Date: 16 November 2018

Representations in relation to application for outline planning permission for up to 27 dwellings at Bridge Cottage & The Old Cottage Lidsey Road, Lidsey, PO22 9PH (ref. AL/20/18/OUT)

We have now reviewed the revised Illustrative Site Plan and updated Transport Study (prepared By Reeves Transport Planning). We note that the amended masterplan (Dwg 1749-02H) is largely unchanged and as such, the comments provided in our letter dated 14 August 2018 remain.

Figure 4.1 – Illustrative Site Plan

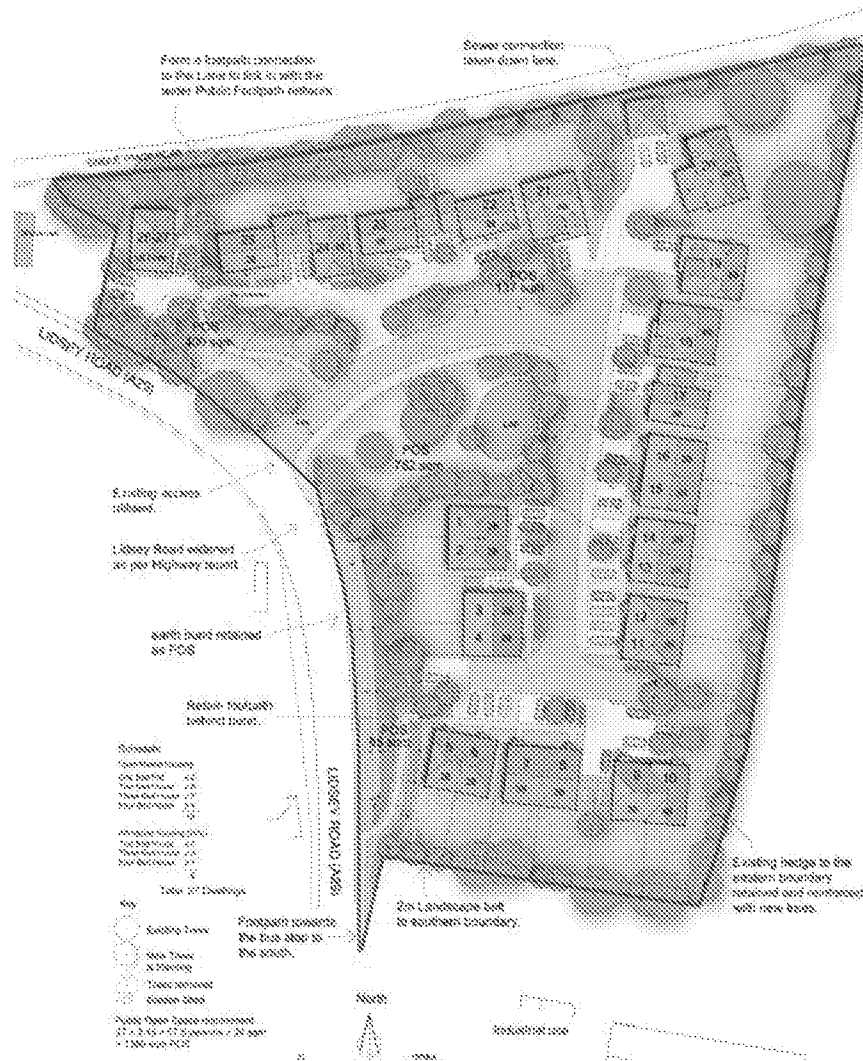
- 1 The internal access road appears to stop short of the site boundary to the east leaving a small strip between the road and the wider BEW site. It is essential that the road is taken to the boundary to facilitate connections to the wider BEW site at the appropriate time and as required by Policy H SP2c SD5.

- 2 Although only shown indicatively, the internal road layout is not suitable for connection to the wider BEW site. As previously outlined, the secondary access road should be made wider to 5.5m to reflect standards set out within the 'Manual for Streets' and as referenced in the West Sussex Design Guide.

- 3 The proposed footways remain inadequate both within the site and to nearby bus stops existing footways. The lack of access to wider pedestrian routes and to the bus stop was noted by WSCC as a significant failing of the current scheme that should be rectified before the application proceeds.
